SUBJECT: Comment Response Letter – Meridian Road (CDR-19-004)

Please see the following responses in ***bold and italics*** for the 2nd review of Bent Grass Residential Filing No. 2.

Figure 10

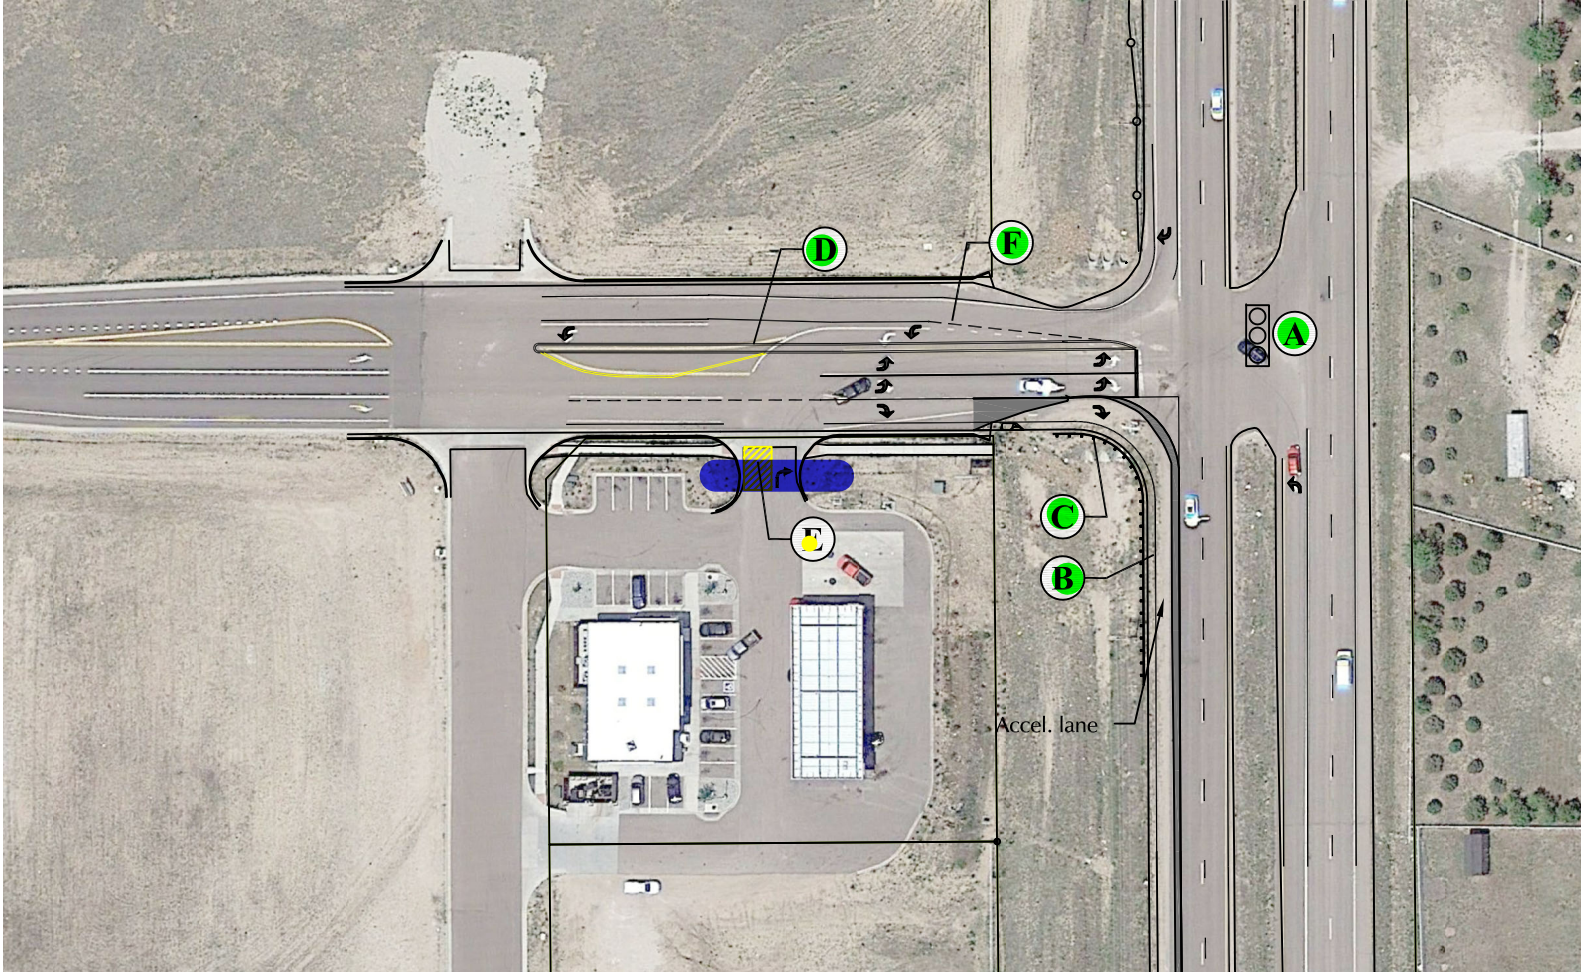
[Show link ADTs](#)

Figure 13  
 Proposed 7-Eleven Access Striping and Signing  
 Bent Grass Meadows (LSC #194900)

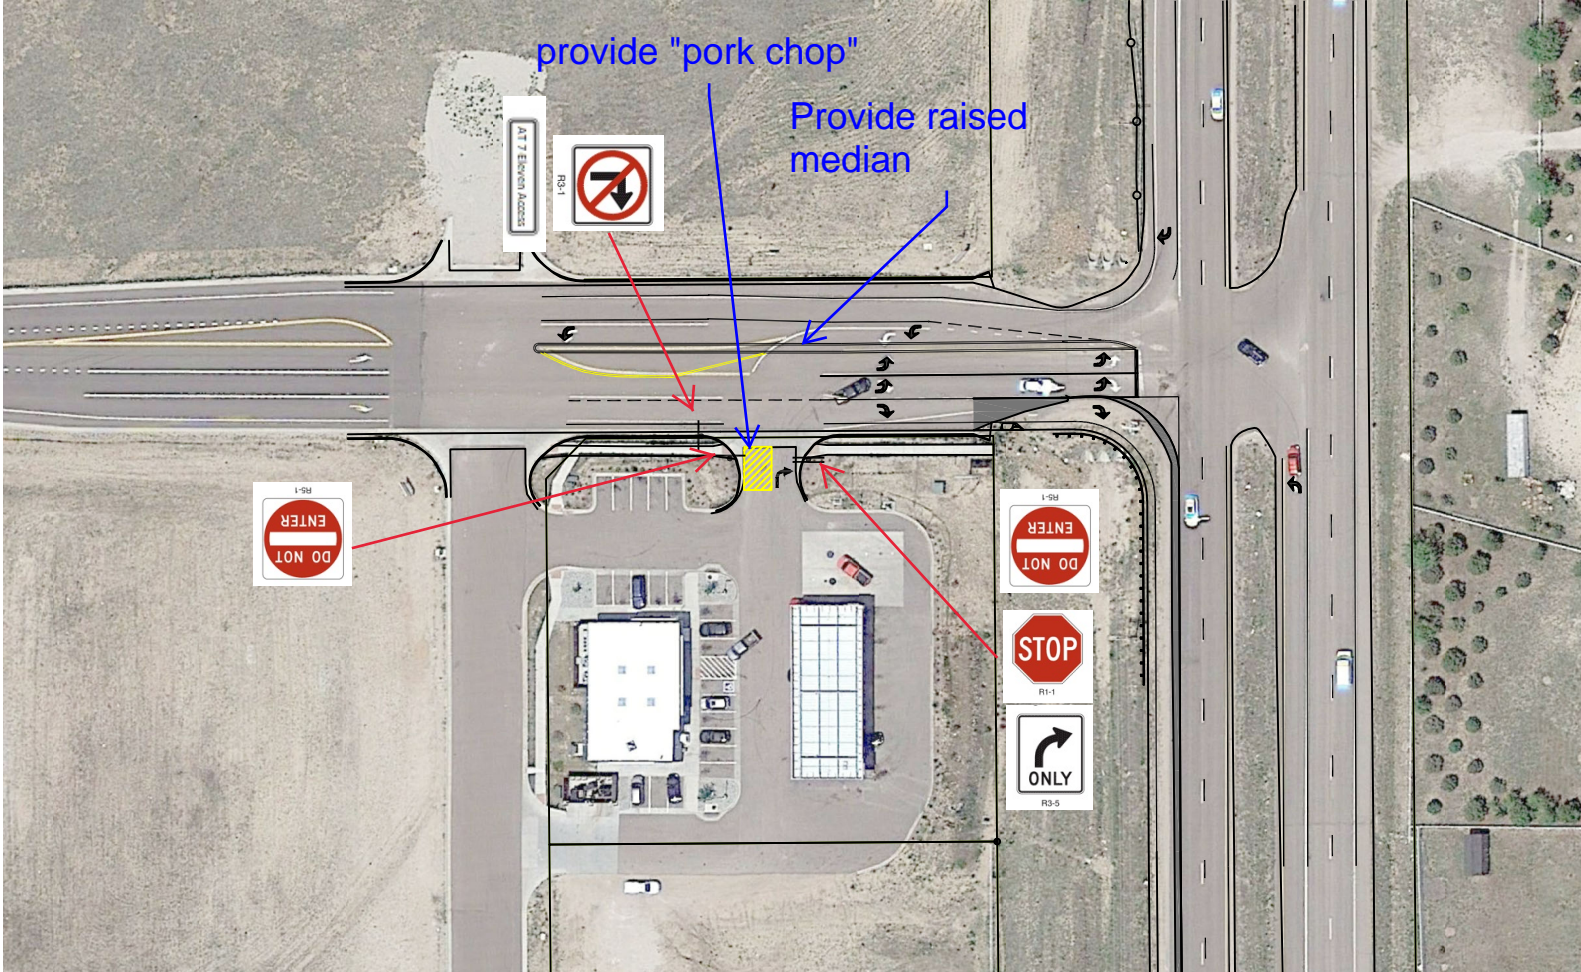
provide "pork chop"

Provide raised median

As the 7-Eleven access has been closed this figure has been removed from the updated memorandum

As the 7-Eleven access has been closed this figure has been removed from the updated memorandum
